**KIRKLEES METROPOLITAN COUNCIL
INVESTMENT & REGENERATION SERVICE**

DELEGATED DECISION TO DETERMINE PLANNING APPLICATIONS

Reference No:	2024/62/93536/E
Site Address:	Homelea, The Knowle, Shepley, Huddersfield, HD8 8EA
Description:	Alterations to convert integral garage into living space, erection of attached garage and formation of new driveway access
Recommending Officer:	Faiza Bano

Officer Report

PROJECT:	Holmlea, The Knowle, Shepley, Huddersfield			
CLIENT:	Mr. M.Smith			
DRAWING:	Proposed L-Ground Floor & Roofplan			
DRAWN BY:	DB	CHECKED BY:	GG	CREATED: 03/12/2024 SCALE: 1:100 @ A3
STATUS:	Developed Design		DRAWING No: 1499/P2-102	REVISION:

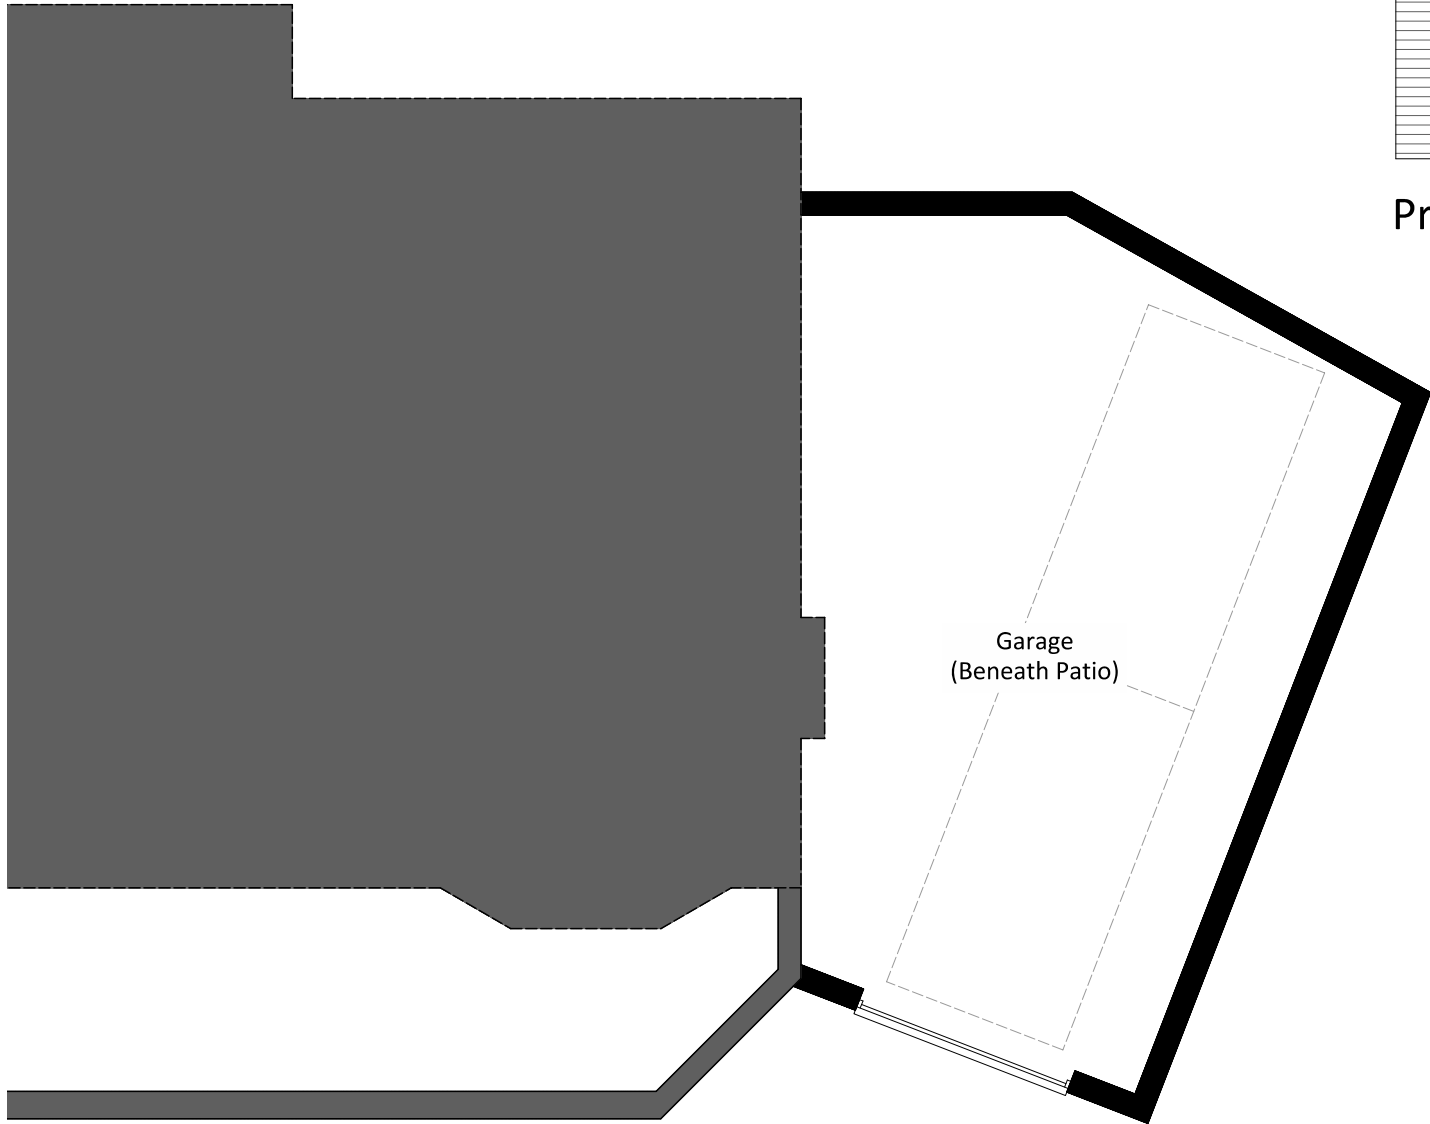
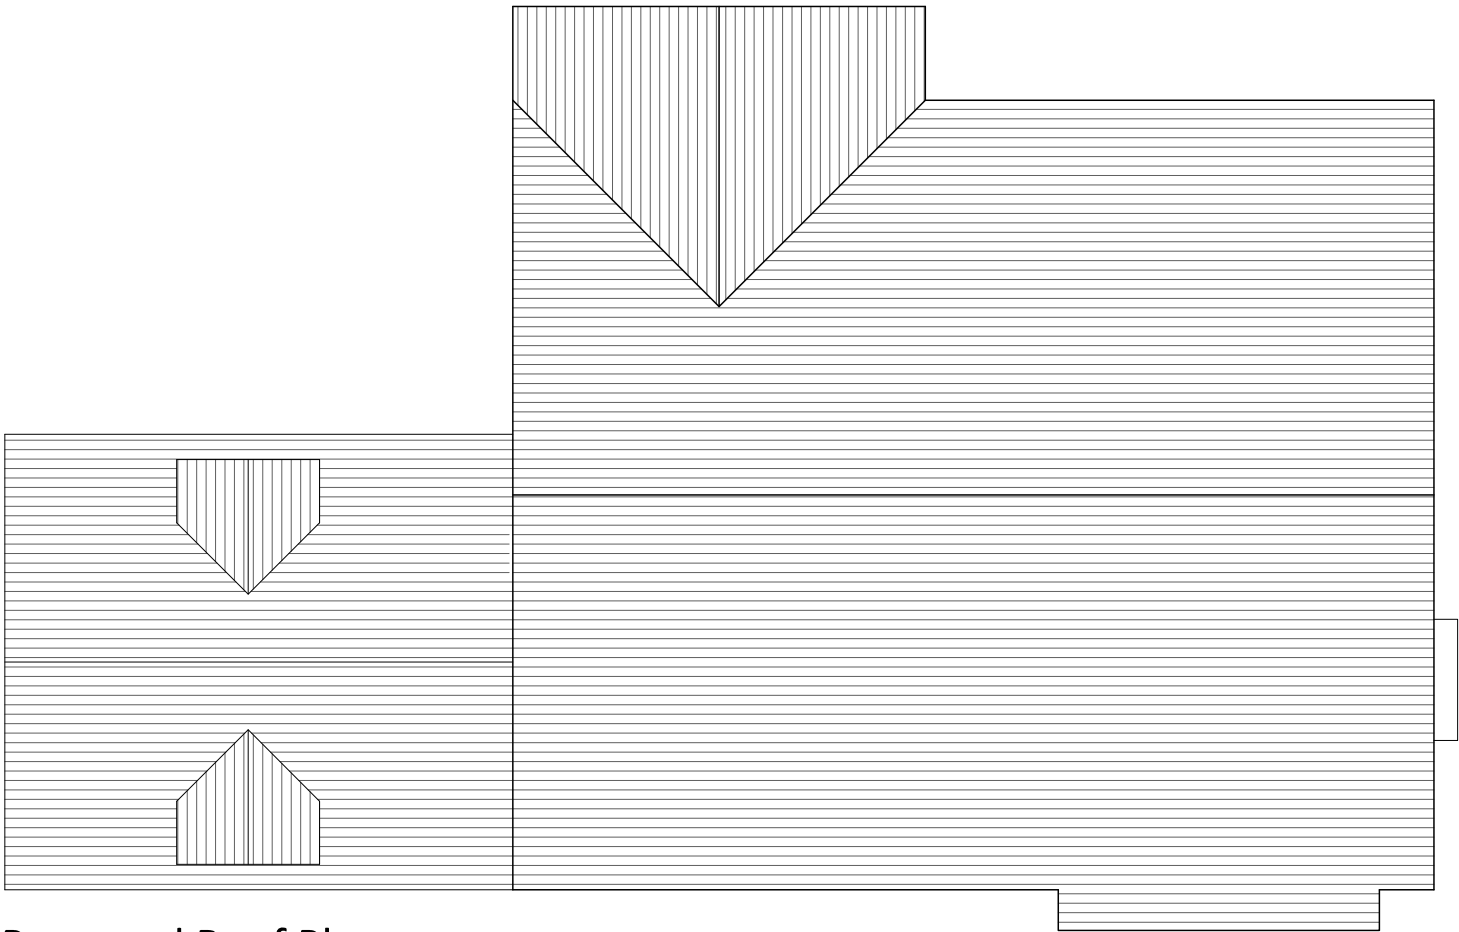
New Access - The new access will be located approximately 16 meters to the northwest of its current location and will serve the proposed double garage and driveway, allowing for on-site vehicle turning so cars can enter and exit the site in forward gear for highway safety reasons. The new access will need to be constructed under a Section 184 agreement with the Council.

Visibility and Safety - The proposed new location of the access is on the apex of a bend on The Knowle and would provide suitable visibility splays in both directions. The residential development to the west of The Knowle (approval 24/90991) includes a 3-meter footpath/cycleway linking the development to The Knowle. Concerns were raised that this pedestrian/cyclist access would conflict with the proposed new vehicular access. However, the two access points will be approximately 30 meters apart, and suitable visibility between the two is available, so this is not viewed as a highway safety concern. The new 3-meter residential development access is expected to generate an increase in pedestrian/cyclist use on The Knowle. However, the current application would not generate any additional vehicular traffic on The Knowle.

3. Notwithstanding the provisions of the Town and Country Planning (General Permitted Development) Order 1995, (or any order revoking and re-enacting that order) any gates or barriers for or over a vehicular access or egress shall be hung as to only open inwards. So long as such gates or barriers are in position they shall be retained to only open inwards.

PROJECT:	Holmlea, The Knowle, Shepley, Huddersfield			
CLIENT:	Mr. M.Smith			
DRAWING:	Proposed Elevations 2			
DRAWN BY:	DB	CHECKED BY:	GG	CREATED: 02/12/2024 SCALE: 1:100 @ A3
STATUS:	Developed Design		DRAWING No: 1499/P2-202	REVISION:

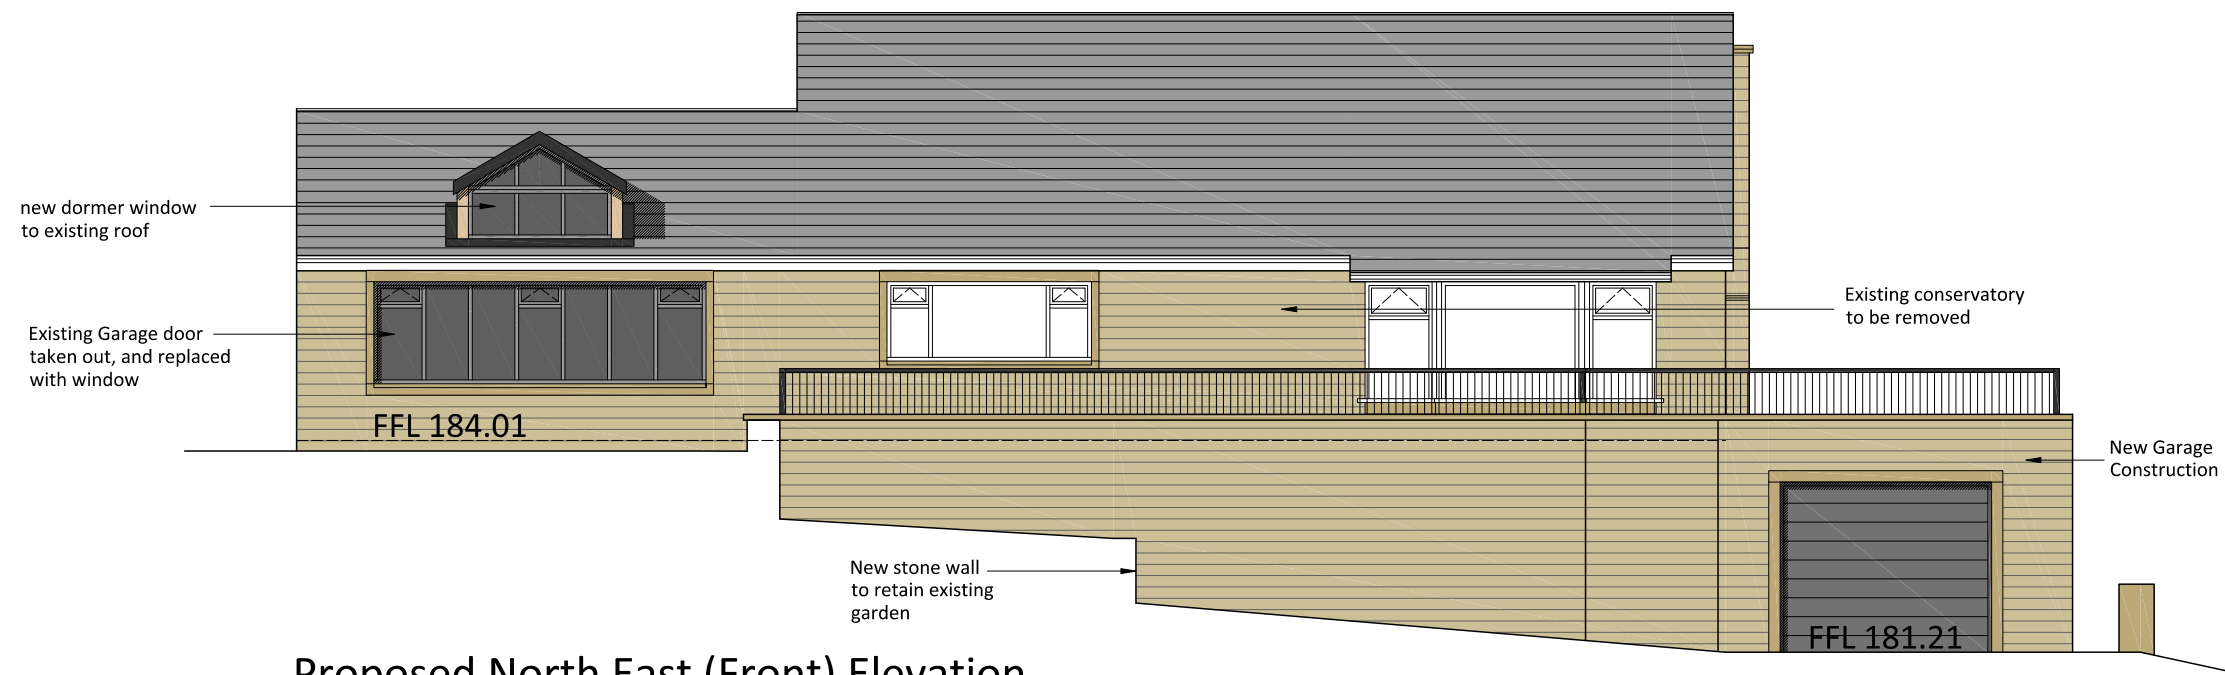
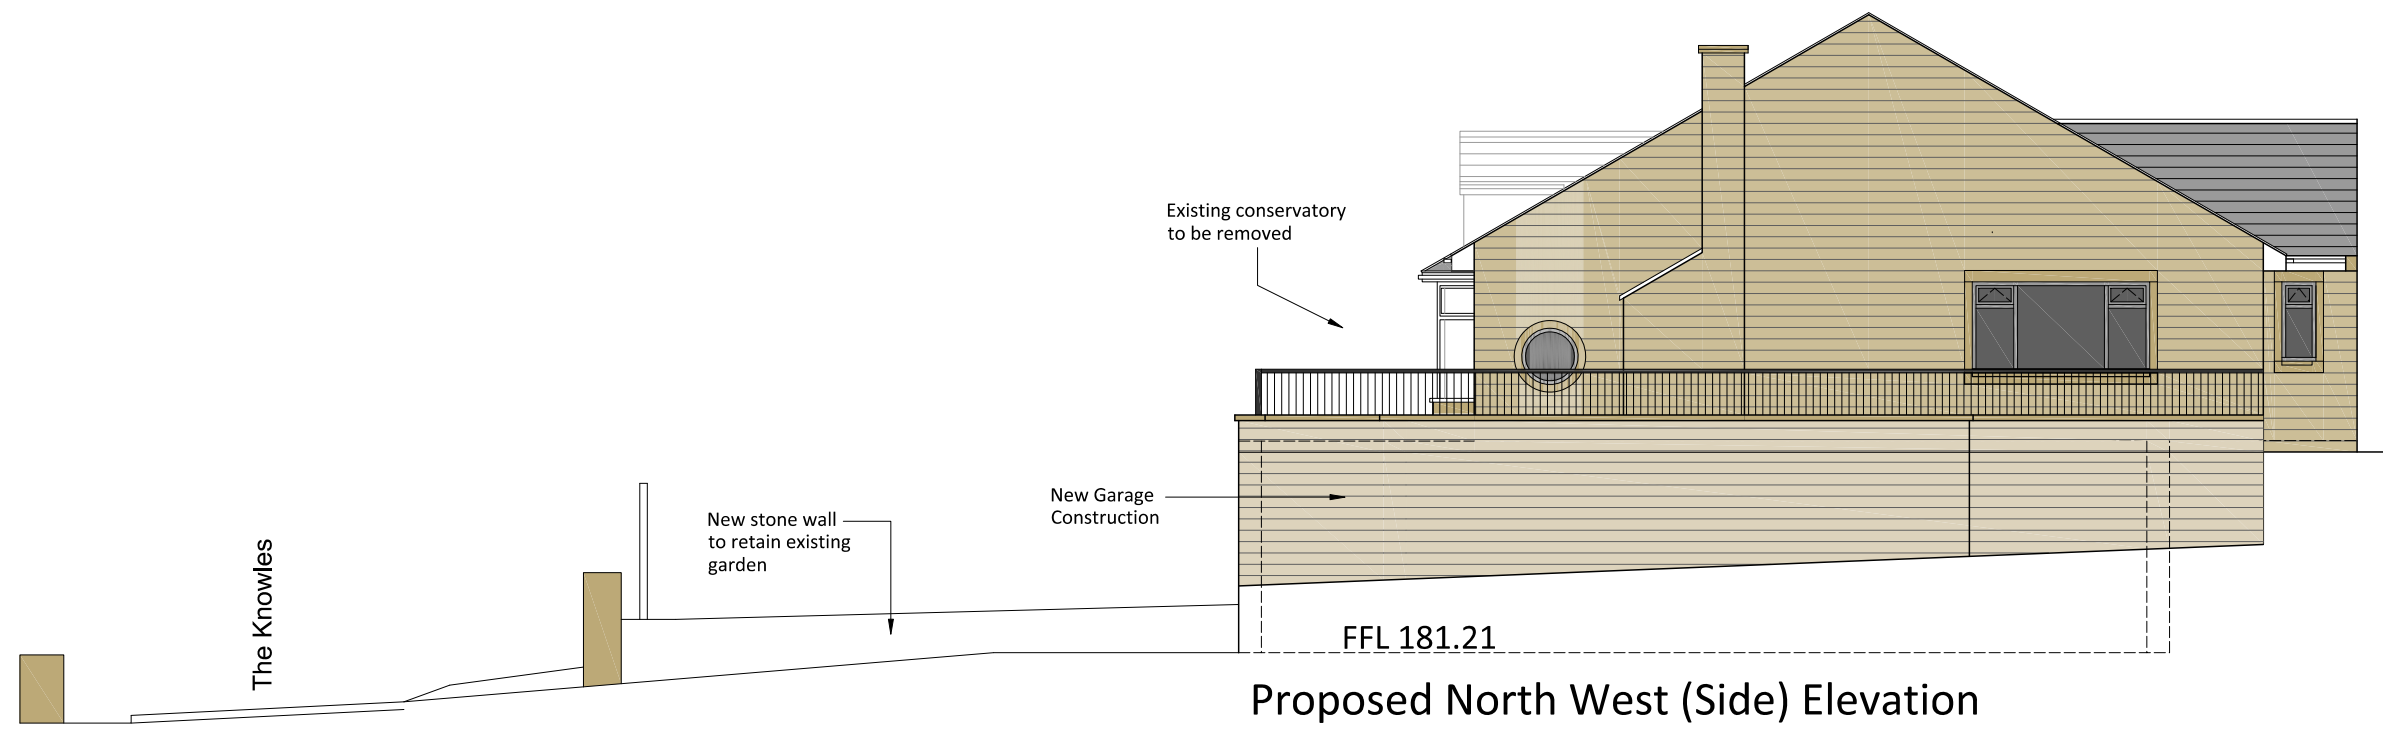
Proposed Garage: The new garage will introduce a significant amount of walling, which could potentially impact the character of the dwelling and the street scene. However, given that the materials and design are consistent with the existing structure, the visual impact is mitigated. The garage is designed to blend seamlessly with the existing architecture, ensuring it does not dominate the appearance of the property.

Dormers: The front and rear-facing dormers are proportionate to the roof and not overly large, maintaining their subservience to the original building. These dormers are designed to enhance the aesthetic appeal of the property without negatively impacting the visual amenity.

Side Extension: The single-storey side extension for the new garage is designed to complement the existing building. It does not appear as an incongruous addition but rather as a harmonious part of the overall structure.

2. The external walls and roofing materials of the extension hereby approved shall in all respects match those used in the construction of the existing building.
